COUNTY COUNCIL'S RESPONSE TO CONSULTATION ON THE FOLLOWING DEVELOPMENT PROPOSAL

Application No: 20/01127/F

Proposal: Demolition of existing buildings. Erection of replacement business units, ancillary hub and associated external works.

Location: Hatch End Old Poultry Farm, Steeple Aston Road, Middle Aston, Bicester

Figure 6.1 Total Parking Accumulation

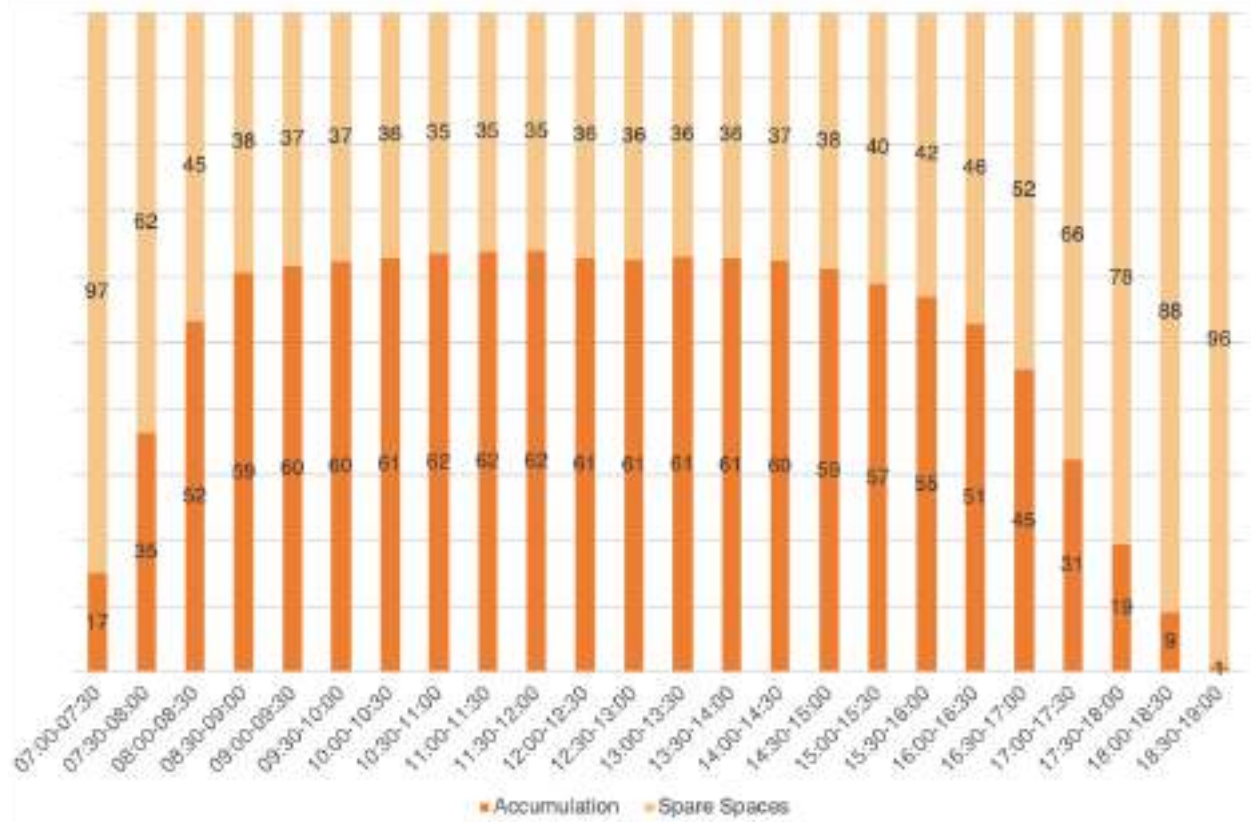
Using the floor area of 3,170m² quoted in paragraph 1.1.2 of the TS and a County standard car parking provision of one space per 30m² for this land use results in a car parking requirement of 106 spaces. The planning application proposes 97 car parking spaces which represents a shortfall of nine spaces. The parking accumulation presented in Section 6 of the TS demonstrates that this shortfall should not result in unwanted on-street parking.

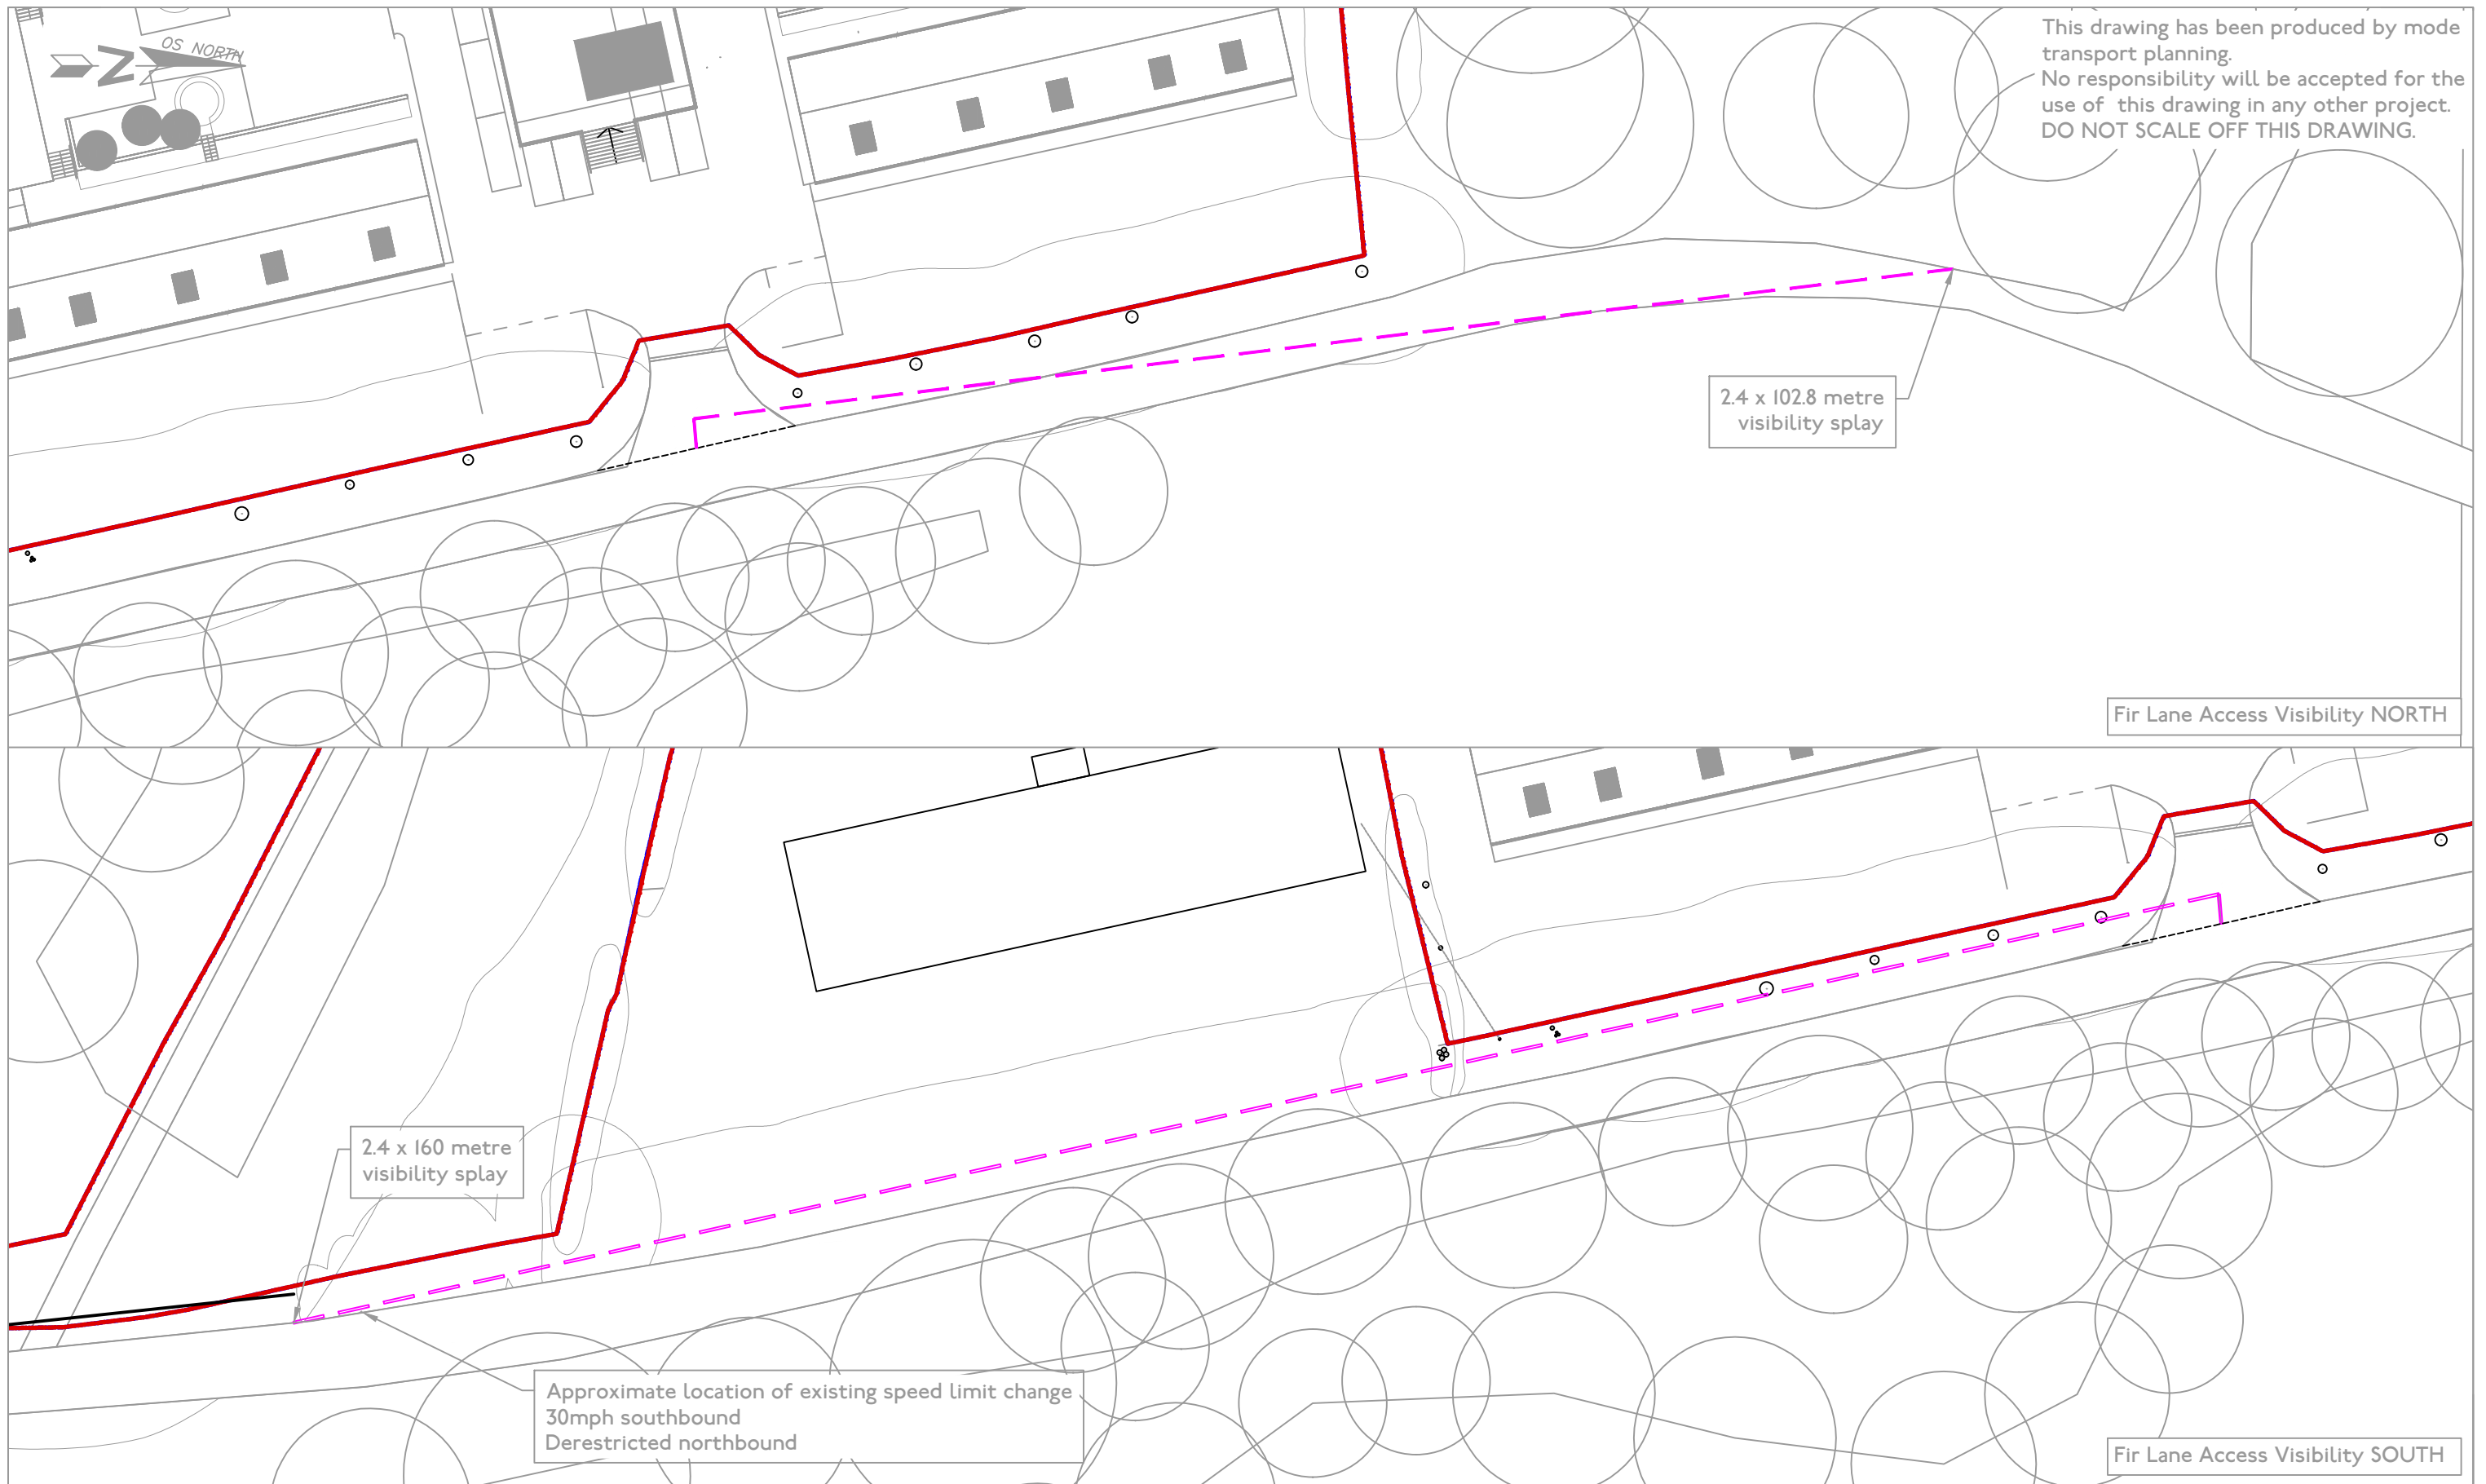
Paragraph 5.6.3 and Appendix E of the TS present visibility splays for the existing site access and notes that they are “...*in-line with Manual for Streets Sight Stopping Distances...*”. The use of Manual for Streets standards on Fir Lane is not necessarily appropriate since it is unlit and has no segregated pedestrian footways. Standards in the Design Manual for Roads and Bridges (DMRB) may be more appropriate. DMRB has been checked and visibility is acceptable against this more rigorous standard.

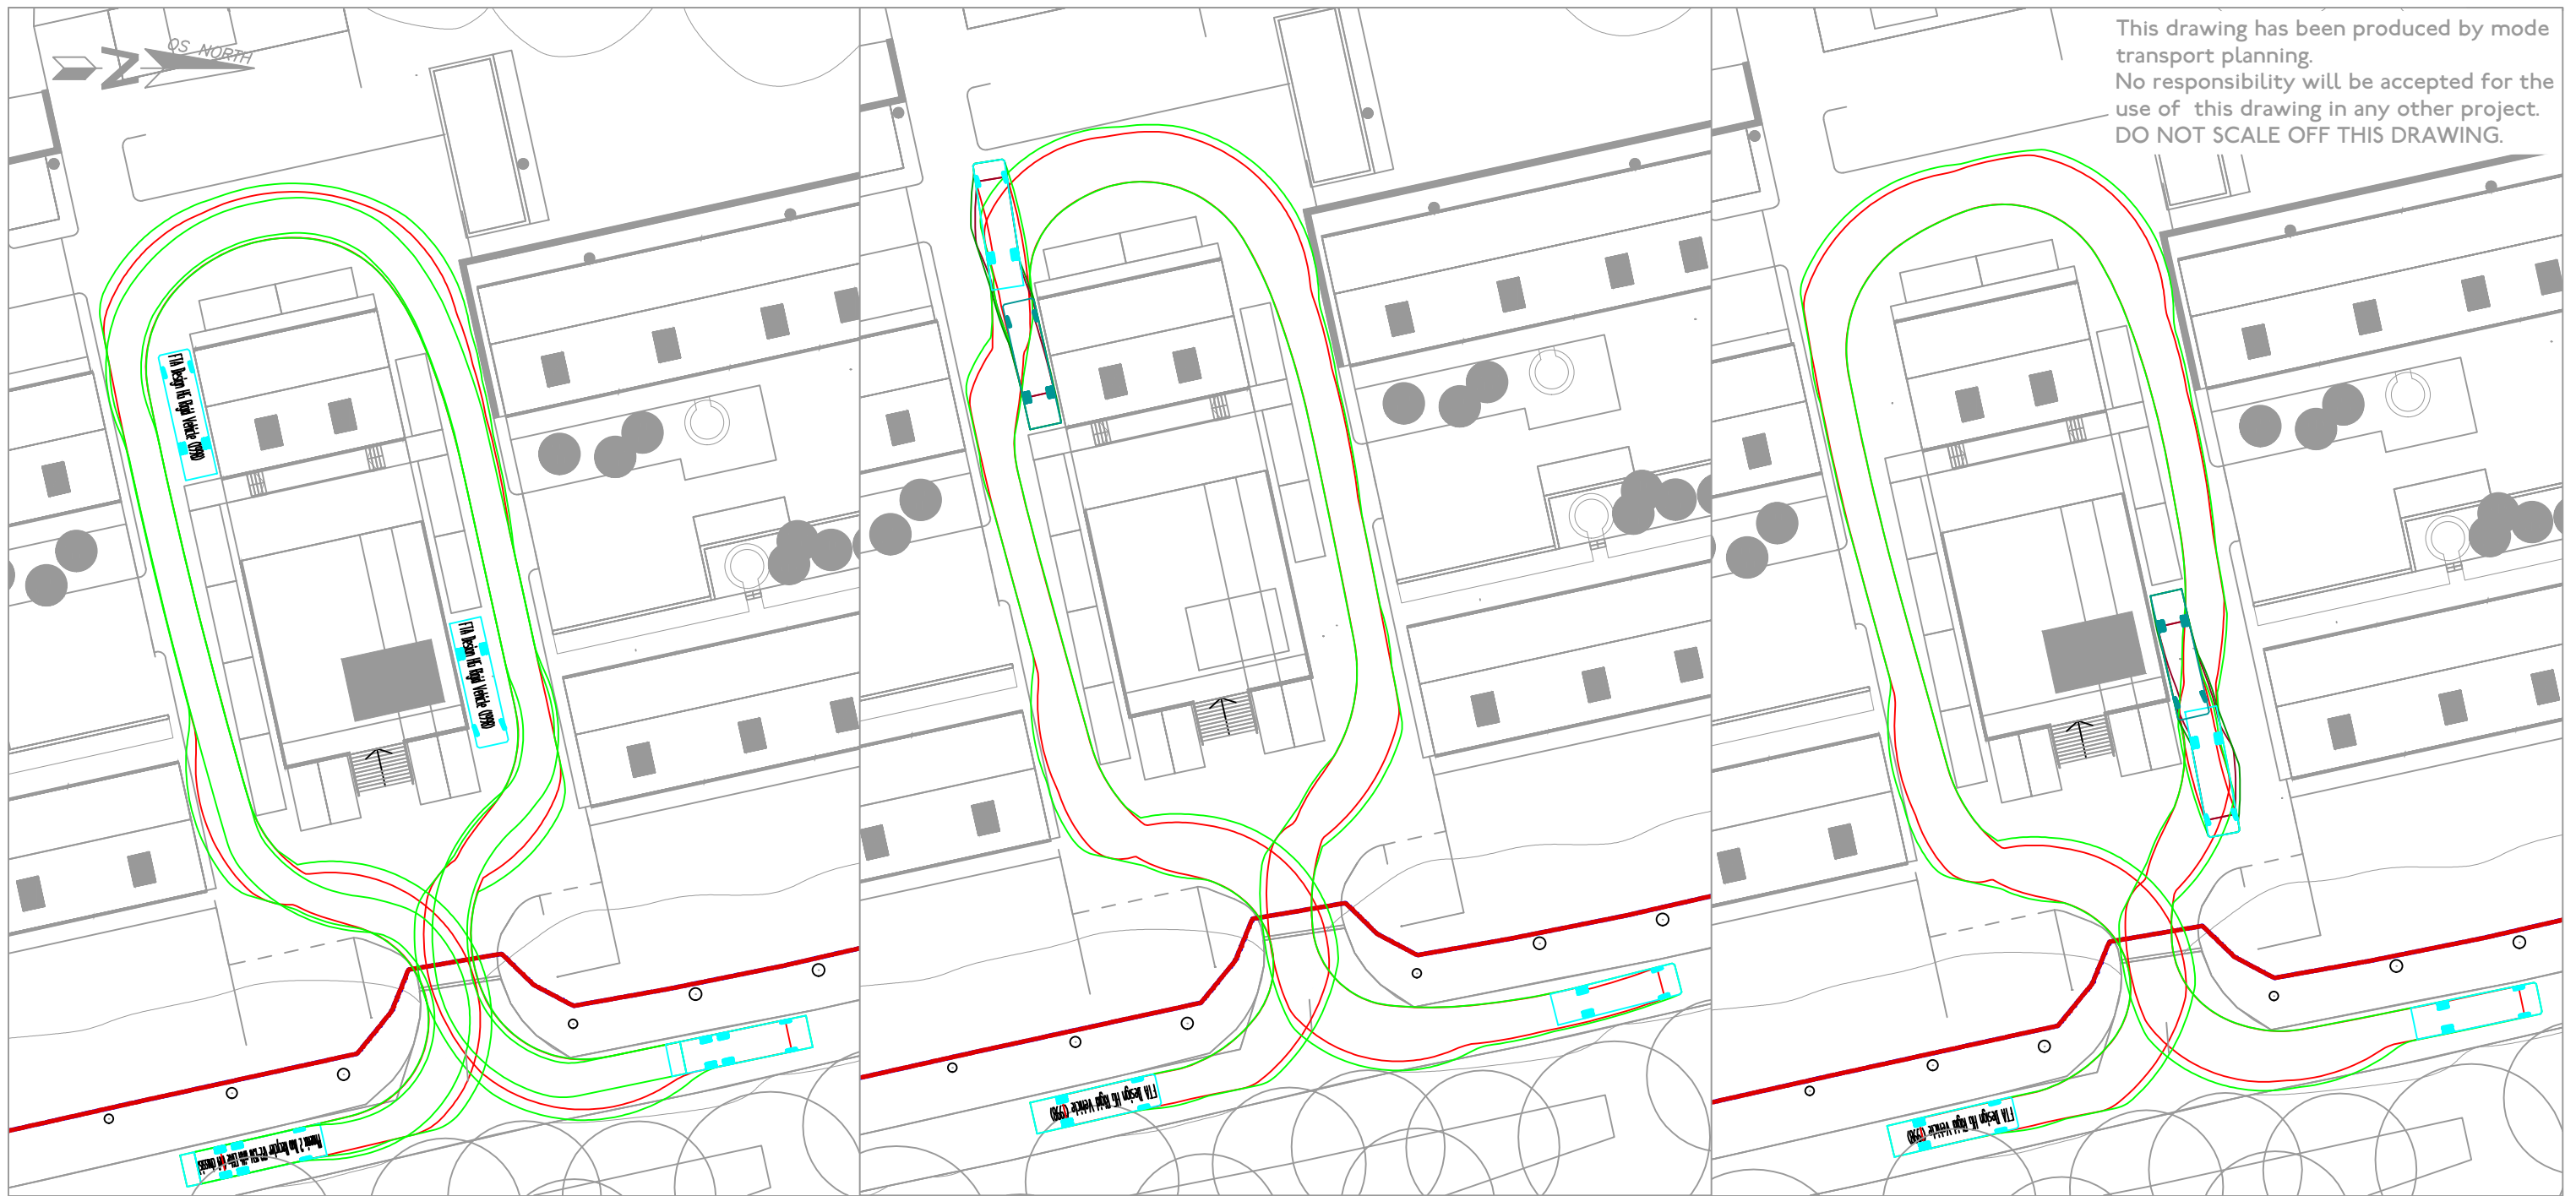
Vehicle tracking, as discussed in paragraph 5.6.4 and presented in Appendix E, is acceptable.
